**Letter of formal objection to application no. 3/2022/1018 for the variation of Condition 2 (Plans) of planning application 3/2020/0424. To allow inclusion of two high level windows to garage at Parsons Croft, Slaidburn Road, Waddington, Lancashire, BB7 3JQ**

drawing number
PL.12

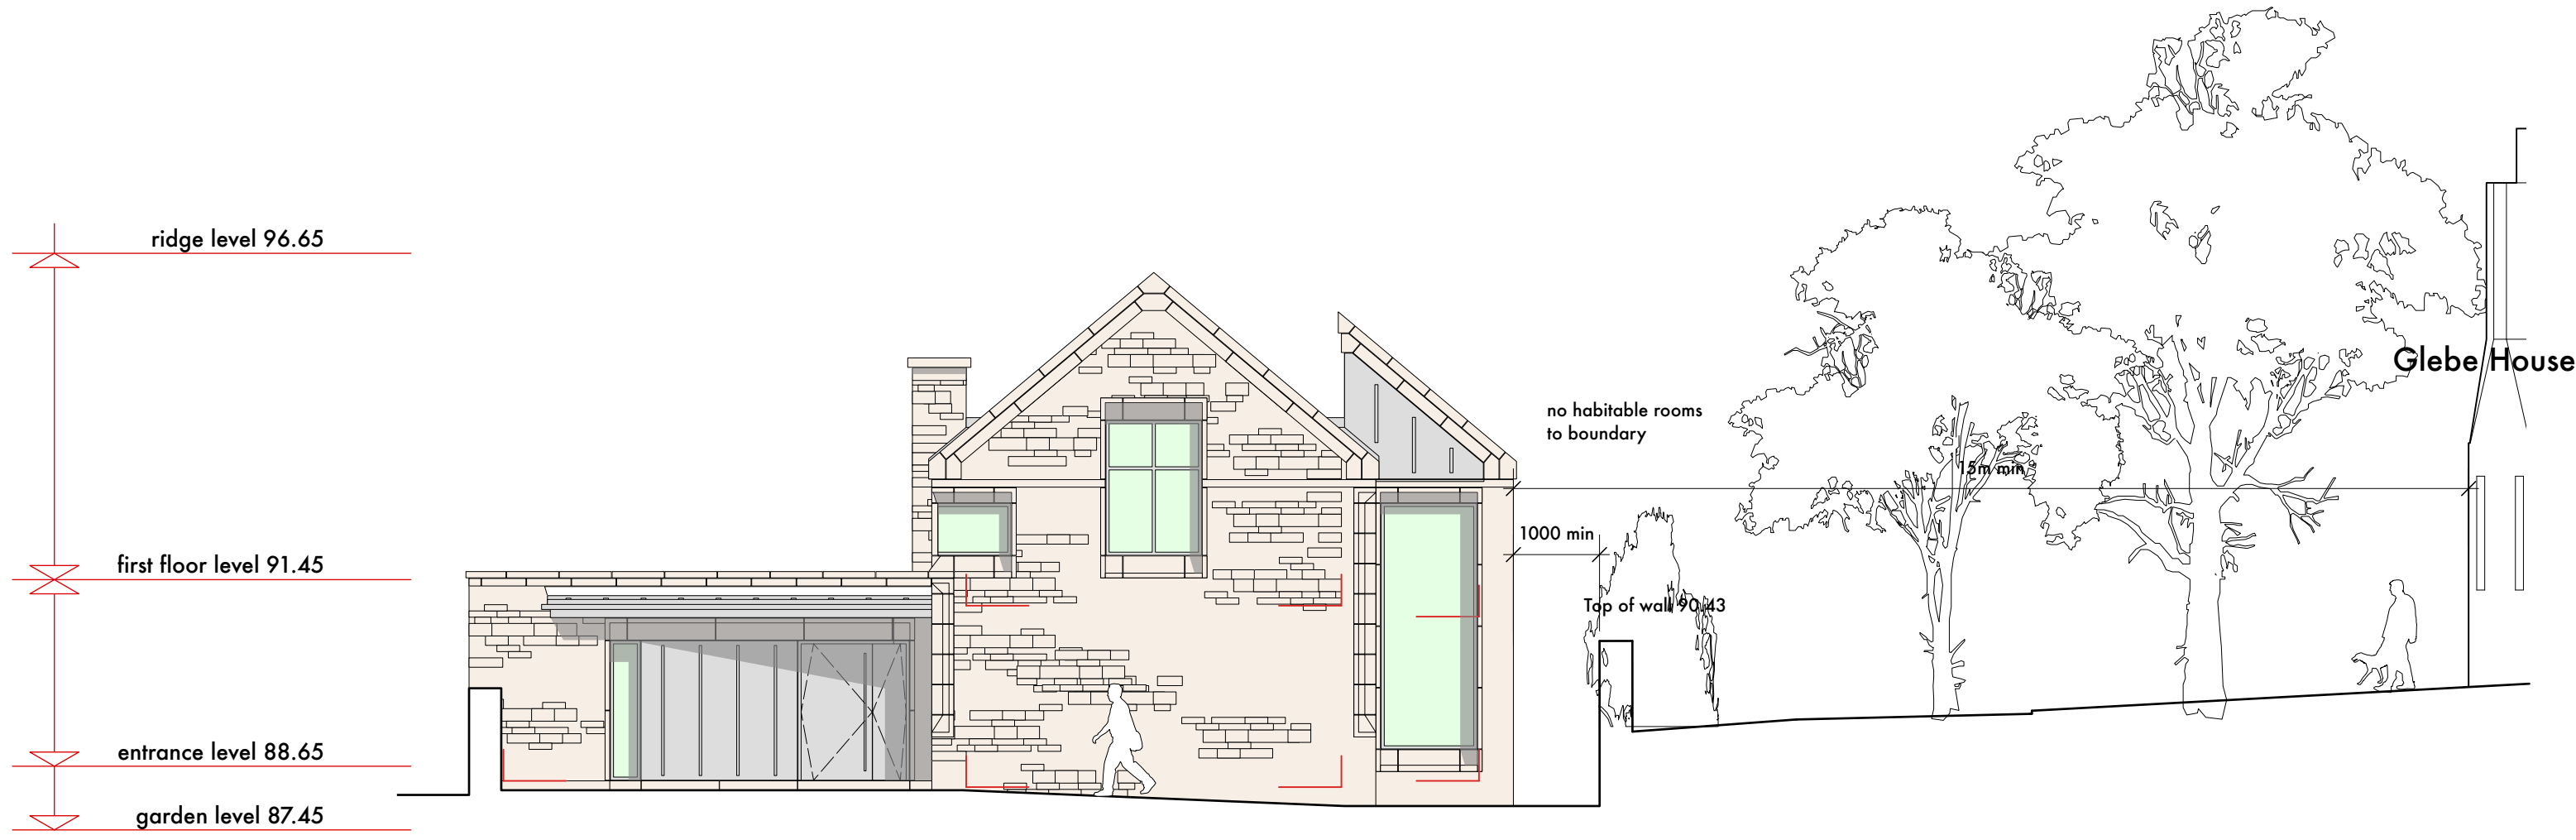
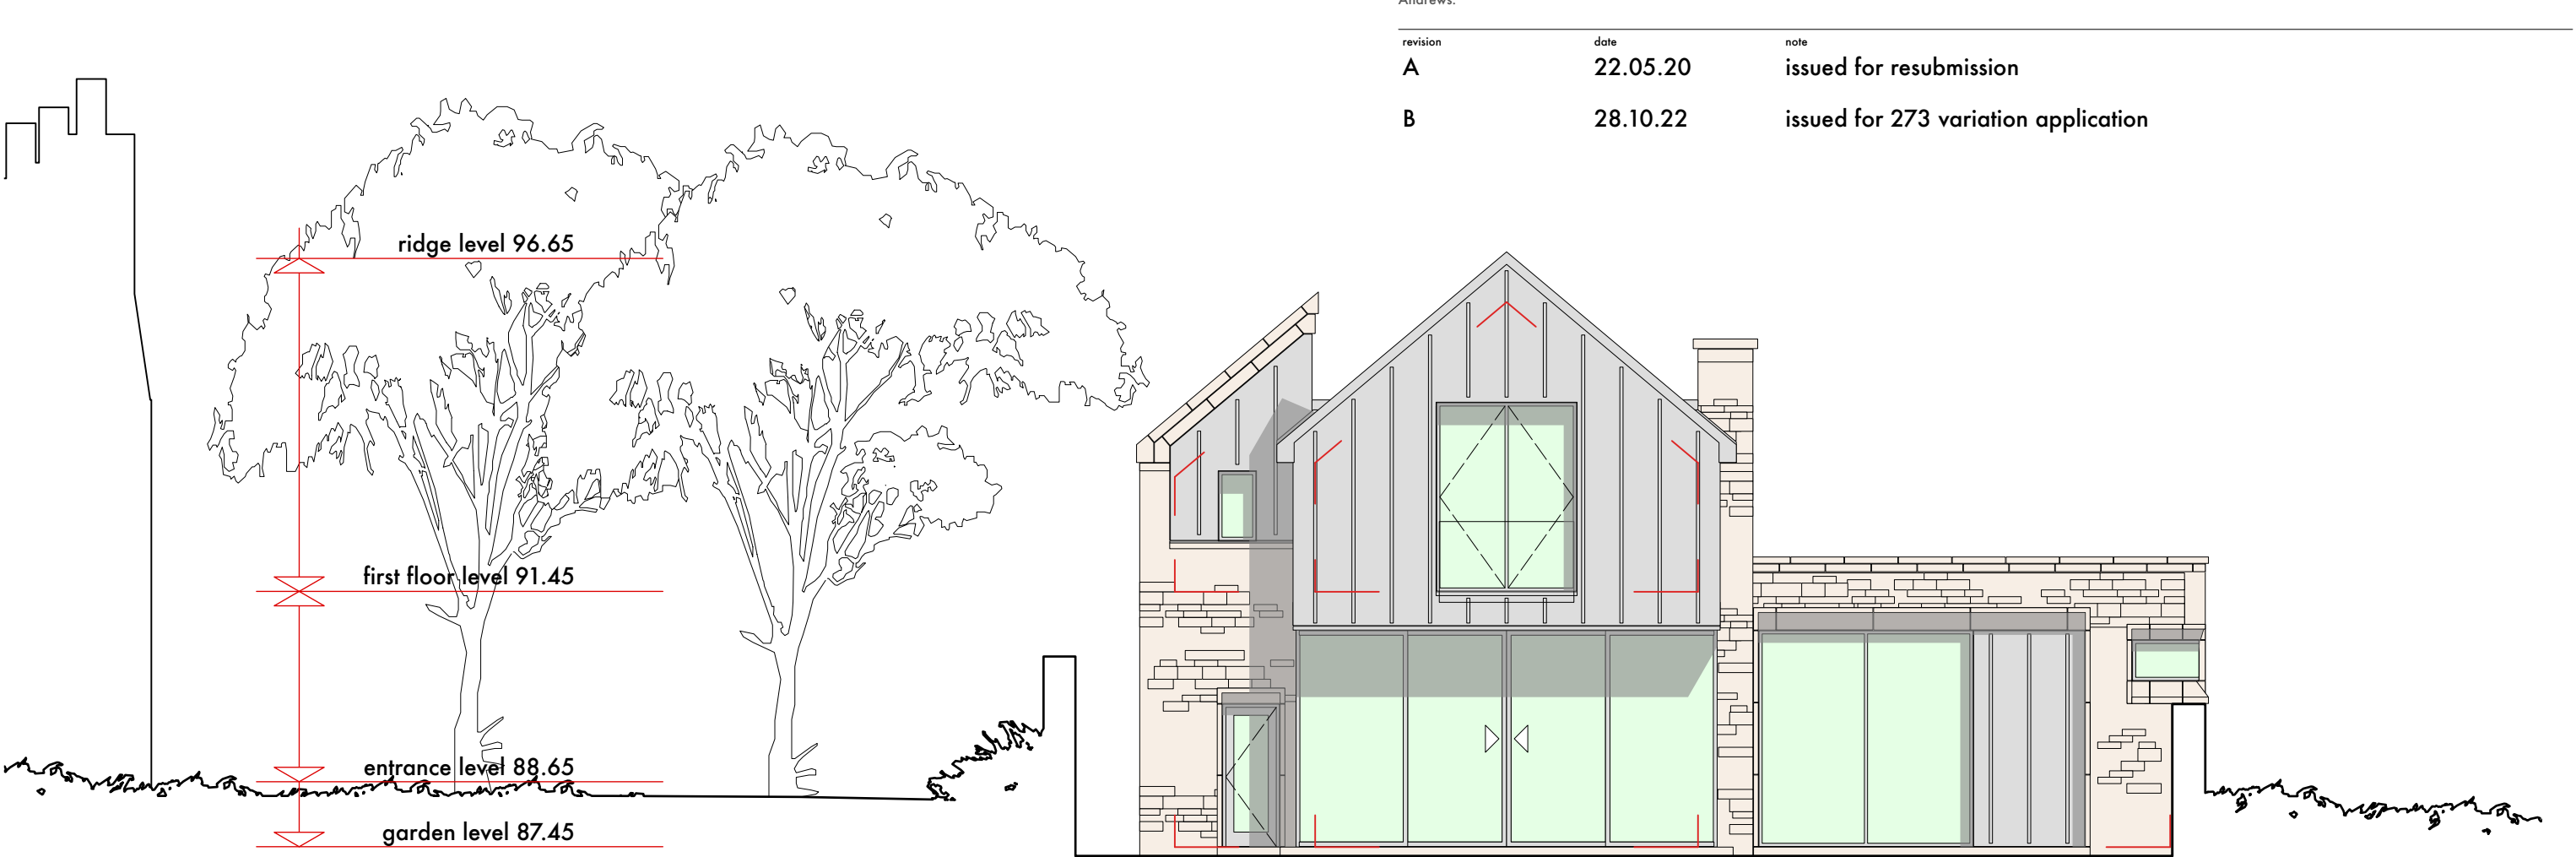
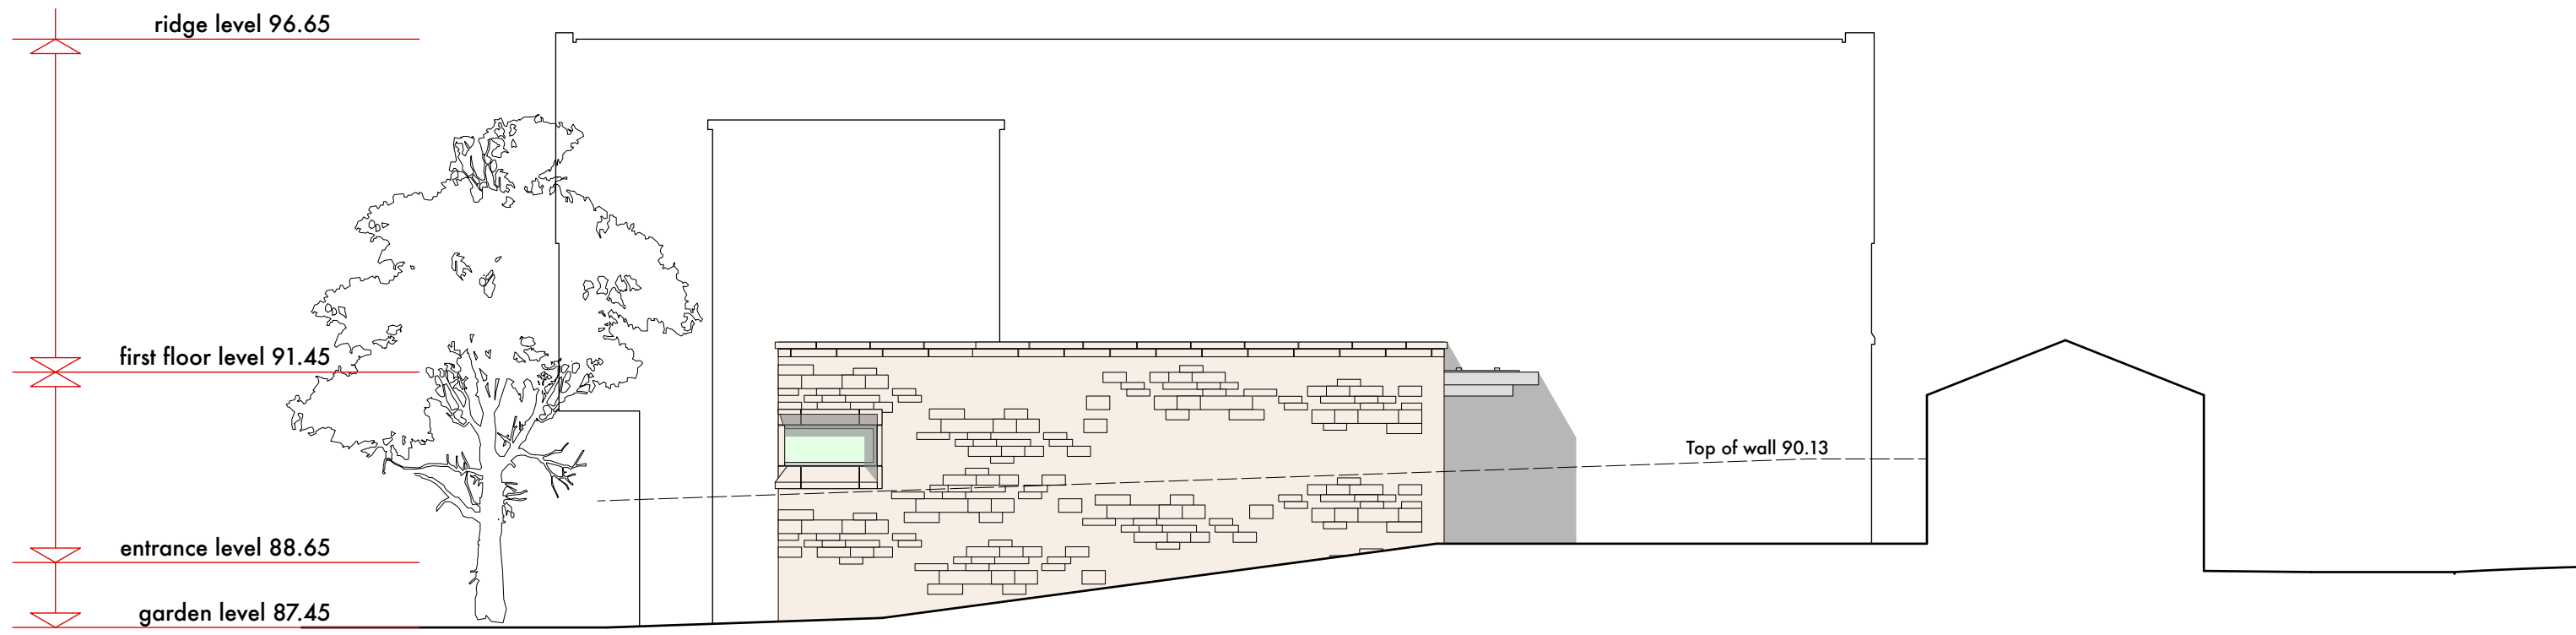
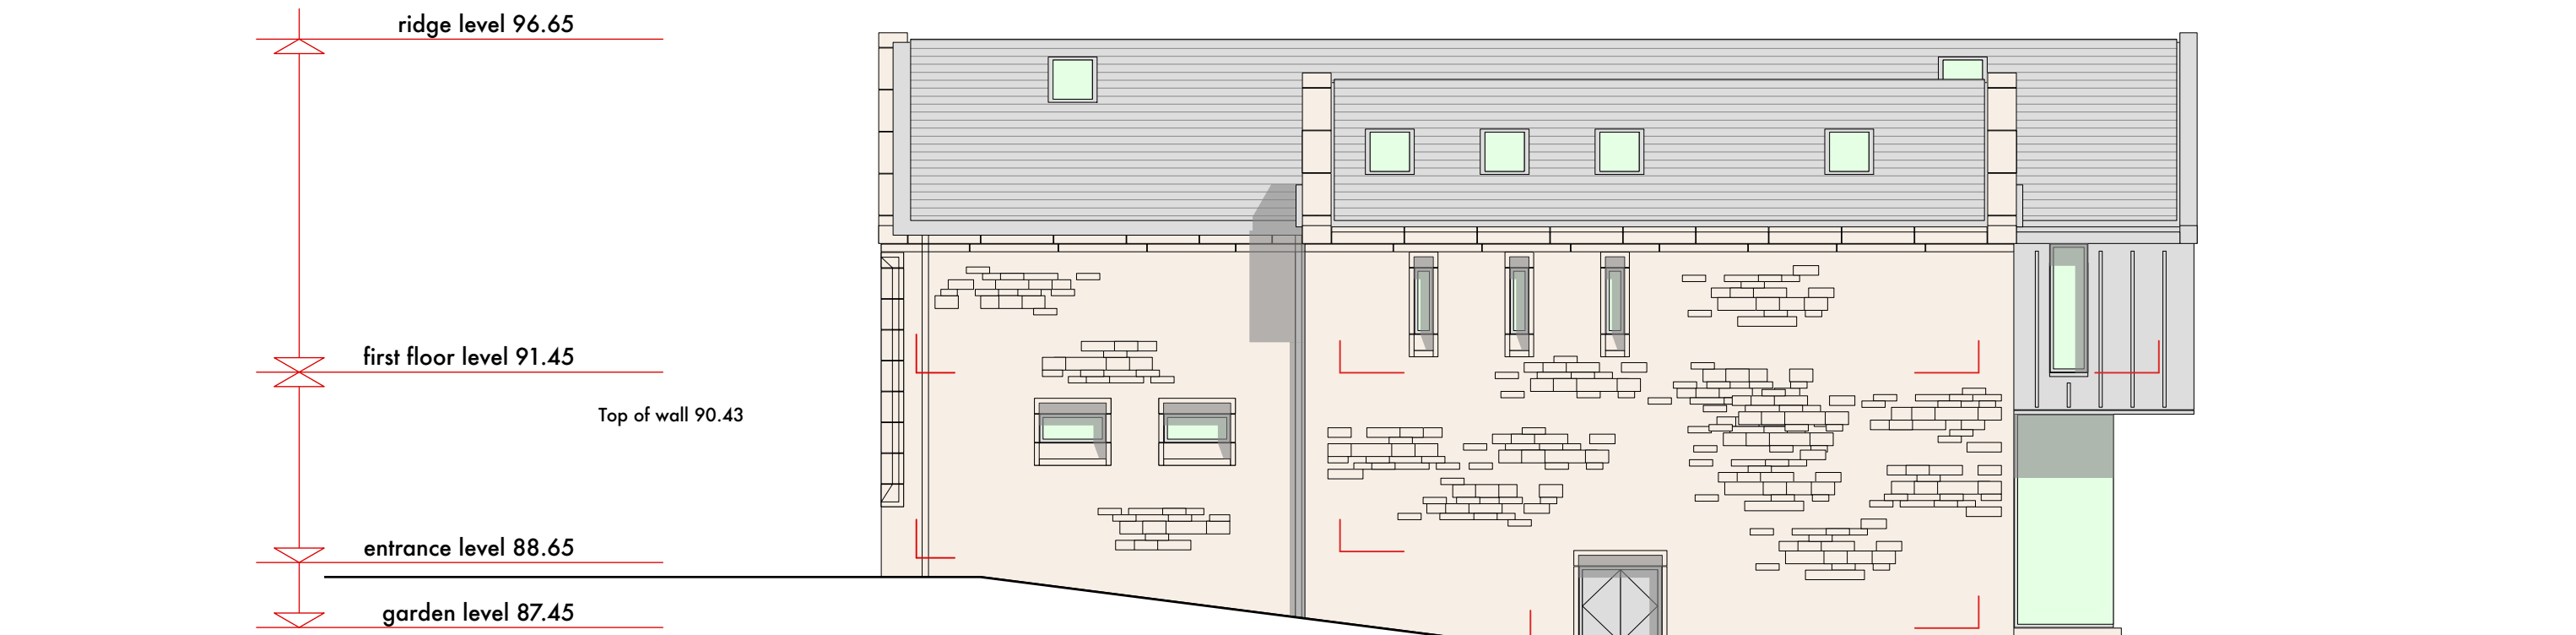
The 2no. windows in question did not form a part of the approved application (3/2020/0424) but have been incorporated into the building nonetheless and therefore the dwelling has not been built in accordance with the approved plans therefore resulting in a breach of the original planning approval. The windows are north west facing and [REDACTED]. The separation distance between the windows [REDACTED] is insufficient at [REDACTED] [REDACTED] been positioned at high level within the garage, [REDACTED]

[REDACTED] There is no mention of these windows being of obscure glazing therefore they are assumed to be of clear glass which is unacceptable given the [REDACTED]

The windows will also contribute to further light spillage from the property which is already very densely populated with a large number of window openings and areas of glazing and would fail to preserve the character and appearance of the Waddington Conservation Area and the setting of the nearby listed buildings due to further glazing to the building. Therefore, the proposal is not in accordance with Policy DME4 of the Ribble Valley Borough Council Adopted Core Strategy.

As part of this objection, we also wish to bring to your attention the proposed height of the building. The building was originally approved (3/2020/0424) with a ridge level of 96.30, however the elevations within this most recent application (3/2022/1018) the ridge level is shown as 96.65, an increase of 350mm. This would result in an extra 15sqm of roofing (approx) to each roof slope [REDACTED]

[REDACTED] It is unknown why the height of the building has been increased but this increase in height has not been acknowledged as part of this application or any other application and should the building have been built at this increased height it is again not in accordance with the approved plans and is a breach of the relevant planning approval. The length of the ridge [REDACTED] and its increased height will further worsen what is an already large and dominant structure whilst having a harmful impact on the setting of the nearby listed buildings and the character and appearance of the Waddington Conservation Area by virtue of its dominant and overbearing nature. As a result, the increased height of the building would not be in accordance with policies DMG1 and DME4 of the Ribble Valley Borough Council Adopted Core Strategy.
